From: Anita Gardner
Sent: 14 November 2018 10:10
To: Planning.Responses
Subject: FW: FW: RE: Blastreat and Greenhurst, Fitzalan Road, Arundel - Application AB/36/18/PL

From: [REDACTED]
Sent: 22 October 2018 16:27
To: Anita Gardner
Subject: Re: FW: RE: Blastreat and Greenhurst, Fitzalan Road, Arundel - Application AB/36/18/PL

3. I attach a plan showing the outline of the registered title plan for the site with the highway land overlaid.

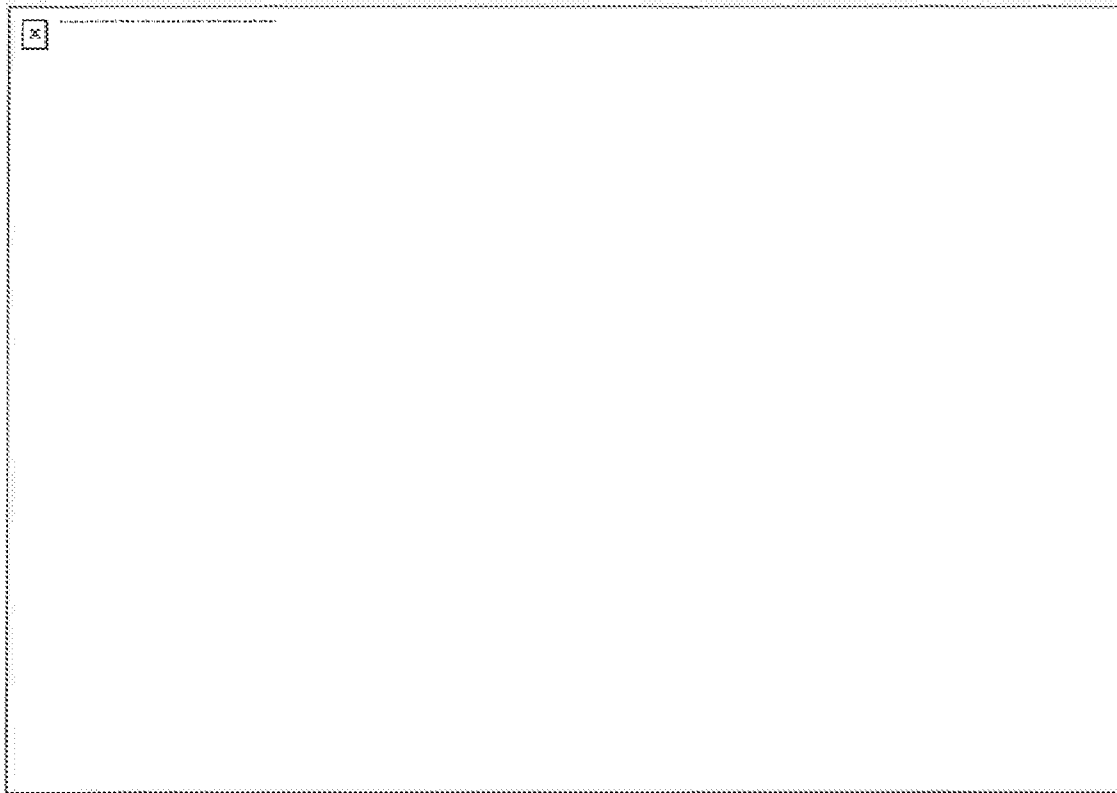
- 1 Stage 1 Road Safety Audit - submitted;
- 2 Neighbouring BT access - I will get our architect to show the BT access details on the Block Plan and Site Plan together with the visibility splay from the proposed access serving the sheltered housing scheme. However, the BT Depot access falls outside of the application site red line boundary. As such the BT access is not affected by the proposed development and the 'flare' remains unaffected as indicated below. The visibility to the BT access is not affected.

The Site Layout has been designed having regard to the Registered Title boundaries for the site and to the existing built form of the Blastreat building taken from the topographical site survey. The overlays generally conform with each other save for slight variations due to distortions of scale. Where the proposed site boundary follows the bend of Fitzalan Road our architect has had regard to the position of the existing buildings on the site as shown on the topographical site survey. This indicates that there is no encroachment of the proposal on the public highway. The proposed new pavement on the south east side of Fitzalan Road between our vehicular access and pedestrian entrance into the proposed building is shown within our site ownership.
